**Consultation Response from KC,
Lead Local Flood Authority**
2020/92657 King James School, St Helen's Gate, Almondbury, Huddersfield, HD4 6SG
Erection of 10 classroom teaching block and formation of car parking area with associated engineering and landscape works (within a Conservation Area)
**Date Responded:
13 October 2020**
**Responding Officer:
Aleksandra Tomczyk**
Responding Ref: 0
Summary

Kirklees Flood Management and Drainage, as the Lead Local Flood Authority (LLFA), OBJECT to this planning application and require FURTHER INFORMATION is provided on the following:

ATTENUATION TANK DETAIL

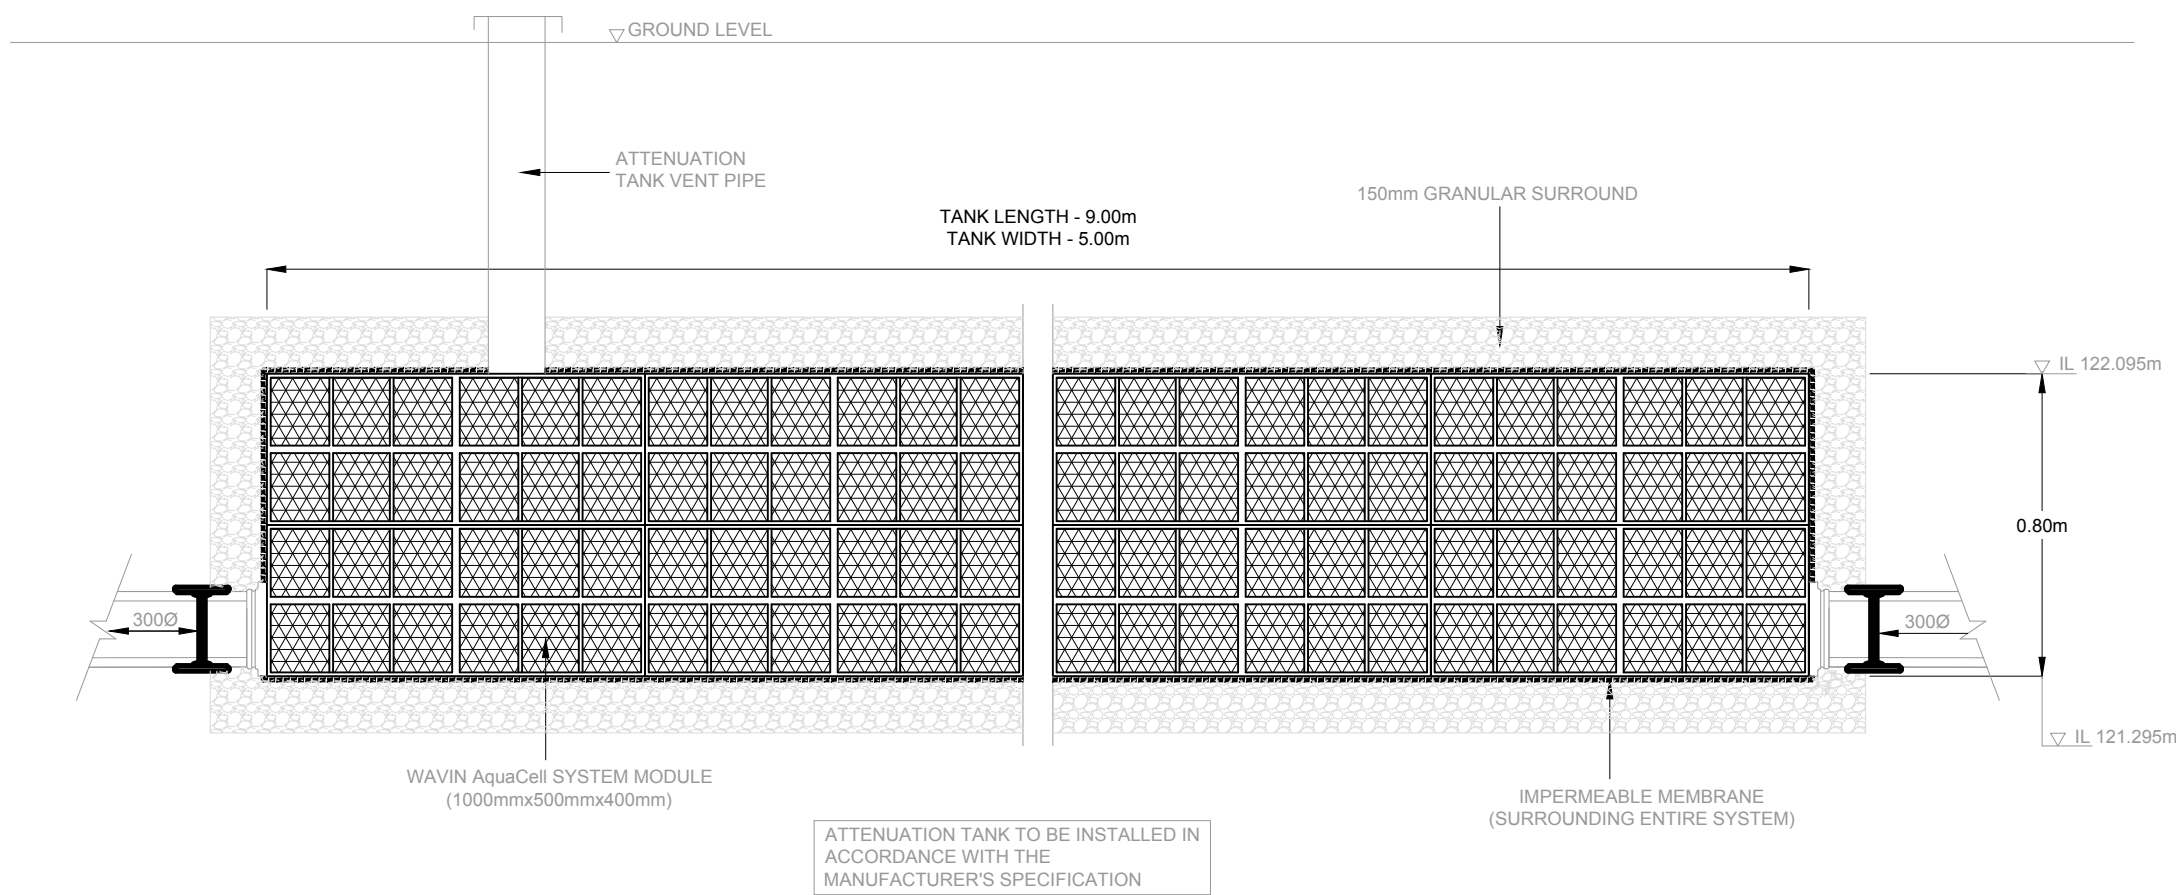
- There are discrepancies between the report and the drawing, with regard to the dimensions and sizing of both attenuation options. This should be reviewed, and updated proposals submitted.
